**Kembla Grange Resource Recovery Facility (SSD_5300)
Comment on the Response to Submissions Report**

Attachment A

Kembla Grange Resource Recovery facility – 50 Wyllie Road, Kembla Grange (SSD 5300) Comment on the Response to Submissions Report Additional comments by NSW Office of Water

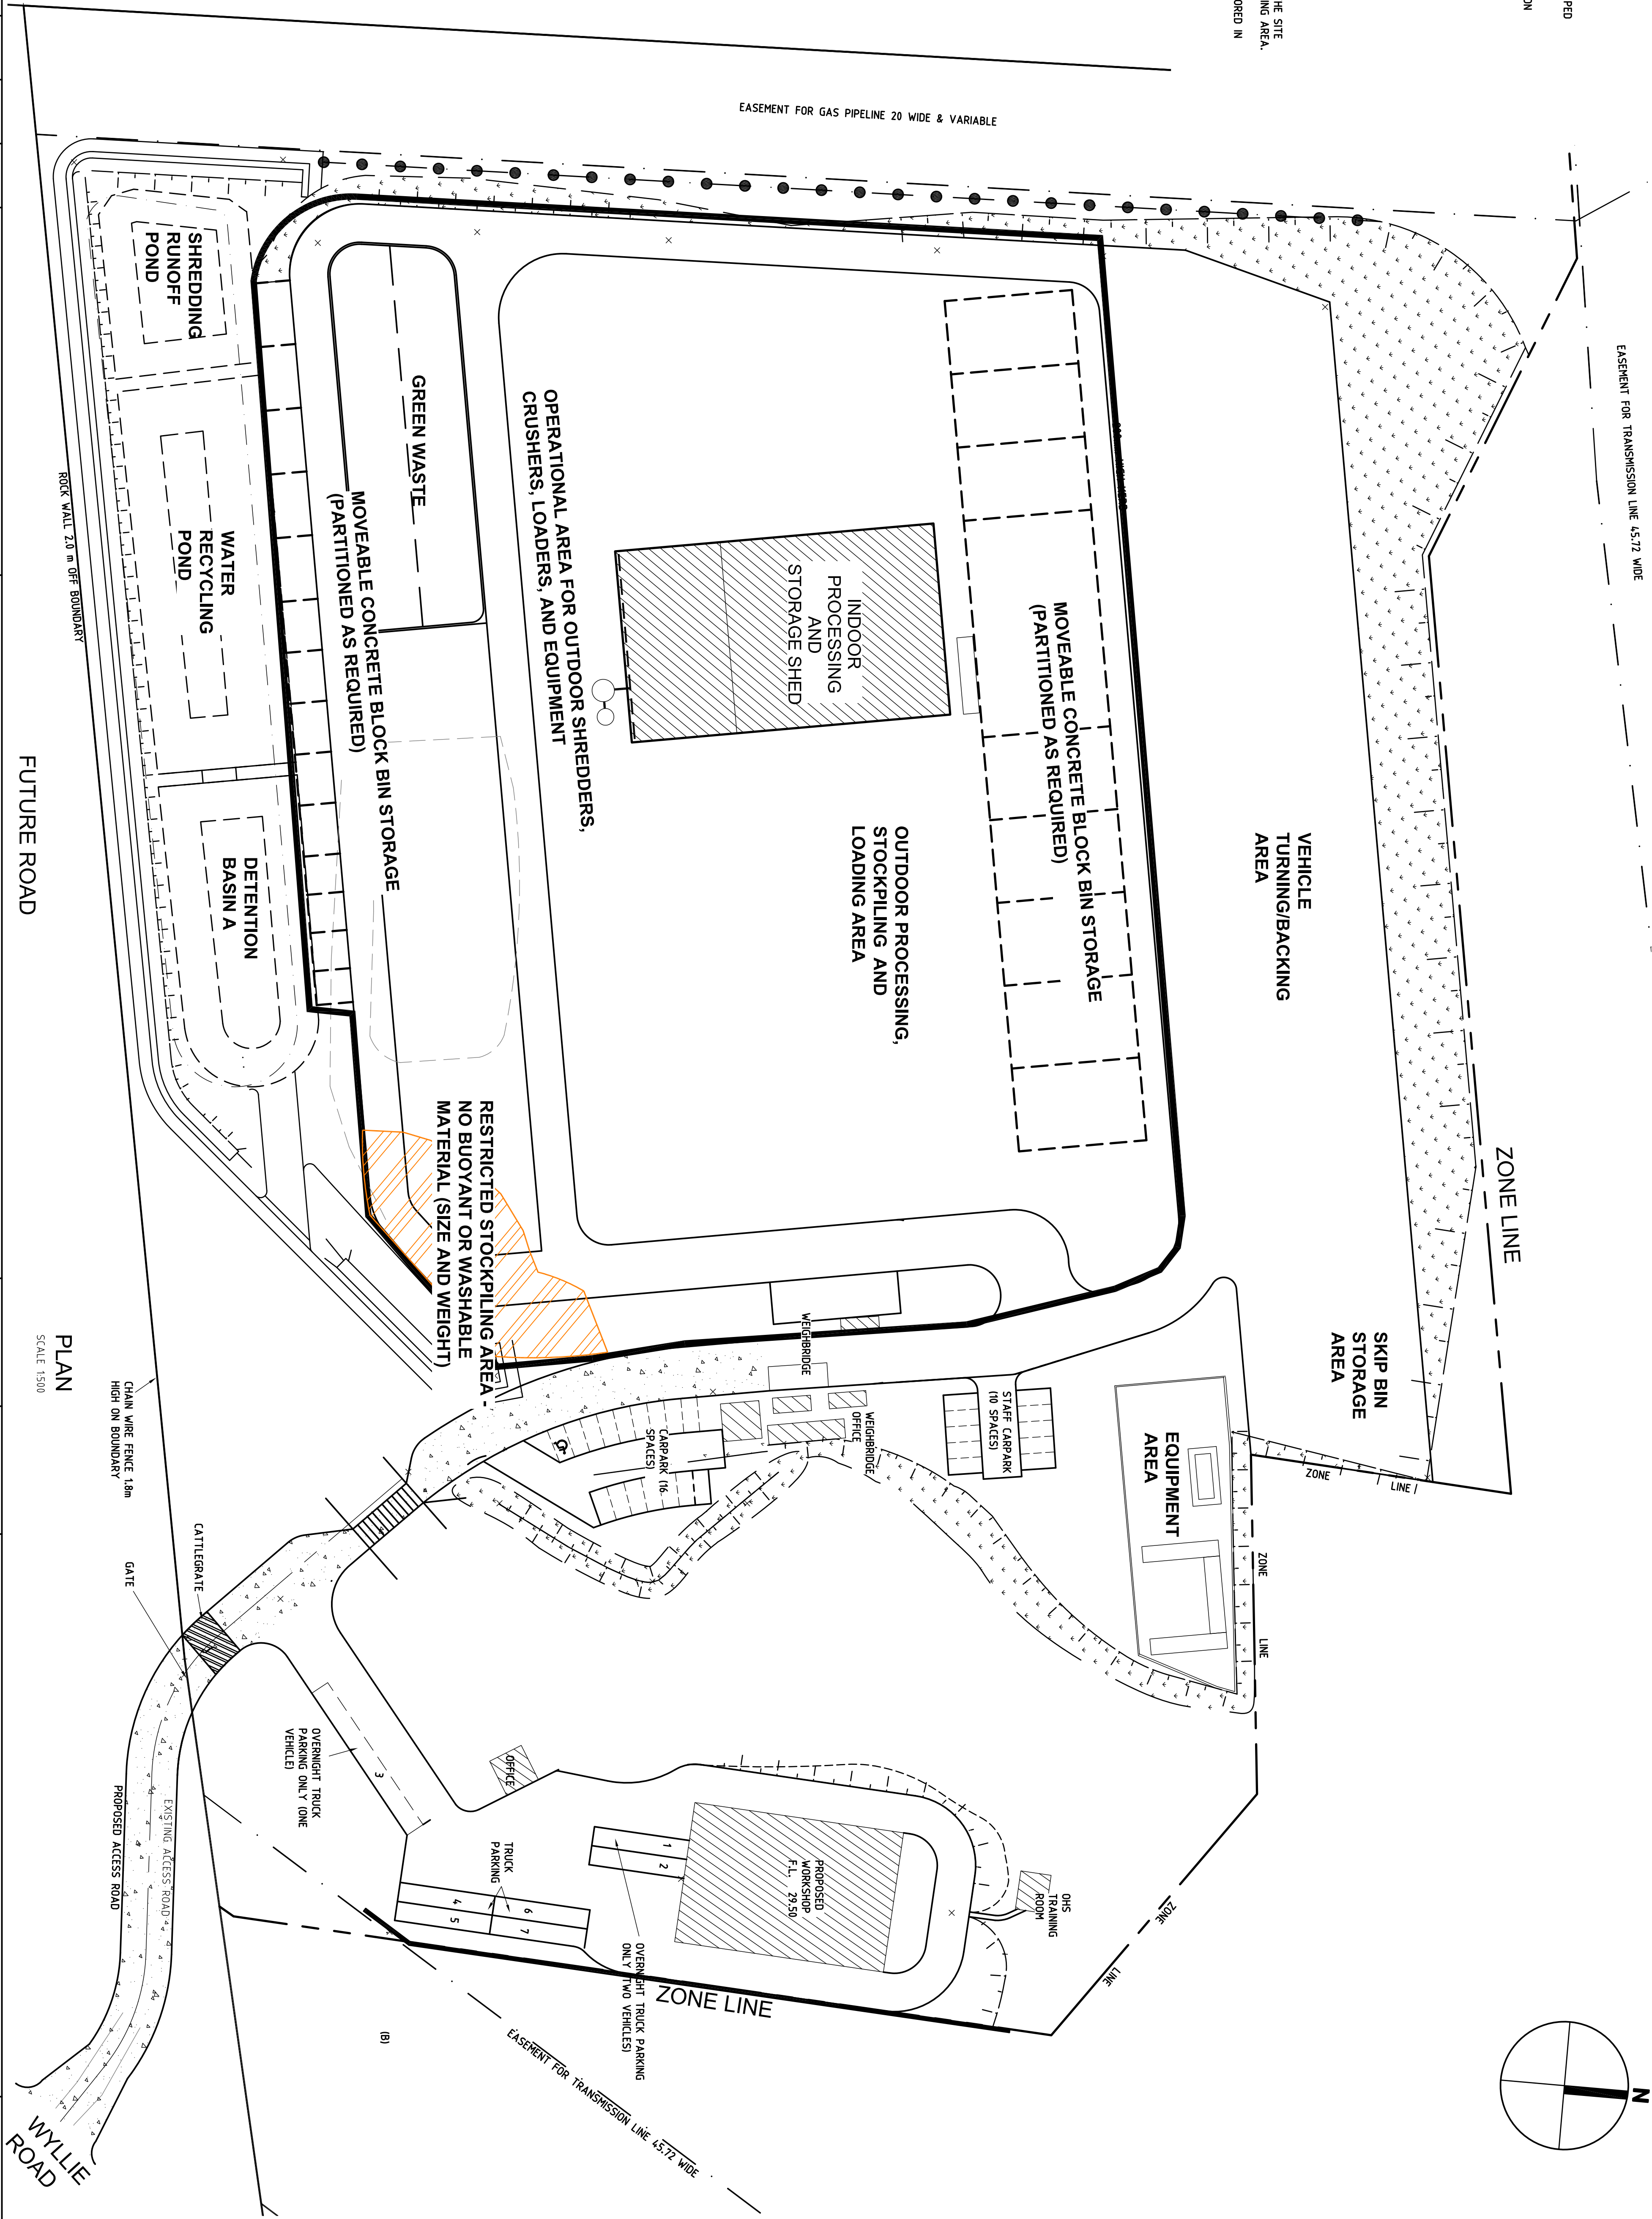
The RTS and revised VMP are confusing in respect to whether any part of the riparian corridor at the site is still proposed to be used as an Asset Protection Zone (APZ), or not, for example:

It is recommended the issue of whether any part of the riparian corridor is to be used as an APZ is resolved prior to approval so as to ensure the riparian corridor is adequately protected, rehabilitated and maintained on the site.

Once the issue is resolved as to whether any part of the riparian corridor is to be used as an APZ, the VMP and Landscape Plan may need to be amended to reflect the outcome.

If the APZ is to still encroach into the riparian corridor, the Landscape Plan needs to clearly show the riparian corridor, areas of APZ encroachment and the riparian offset areas. Section 1.2 of the revised VMP indicates the areas of change to the VMP include an up to date Landscape plan in Appendix D. This plan is meant to show the reduced area of the fully structured riparian planting due to the APZ, the offset planting and the remaining unaffected riparian planting but the plan is not included in Appendix D. The Landscape Plan included in Appendix 9 of the RTS submission is dated 10/12//2012. It is requested a copy of the updated Landscape Plan is provided.
